CR 2012/533
505DA207
24 February 2012

**MANNERING COLLIERY
EXTENSION OF MINING MODIFICATION (06_0311 MOD 1)
ENVIRONMENTAL ASSESSMENT(EA)**

RMS Response and Requirements

Figure 2.5 **Proposed intersection layout**

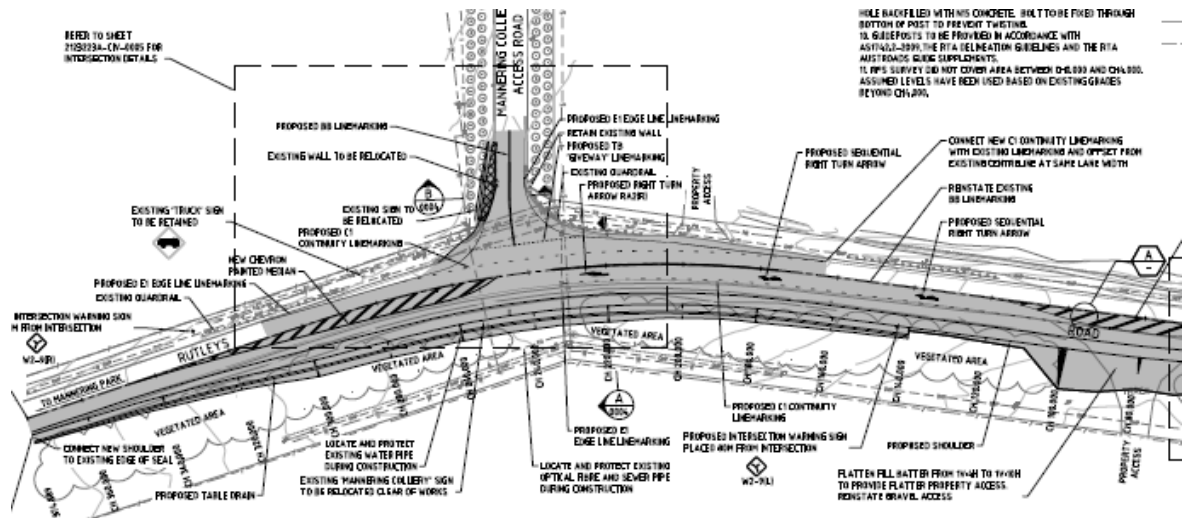
- The traffic report included in the EA identified that the additional volumes generated by this proposal had little impact on the Rutleys Road/Mannering Colliery Access Road intersection. The Rutleys Road/Mannering Colliery Access Road intersection is likely to be upgraded by the end of 2012. The intersection upgrading is a matter for Wyong Shire Council and the RMS would support these works to further increase safety and operation of this intersection
- Section 117 (2) direction 3.4 (*Integrating Land Use Development and Transport*) under the *Environmental Planning and Assessment Act 1979*, should be taken into account in relation to the provision of adequate access to public transport. The provision of alternative transport modes to private motor vehicles and the facilities required to encourage the use of these modes should be included.
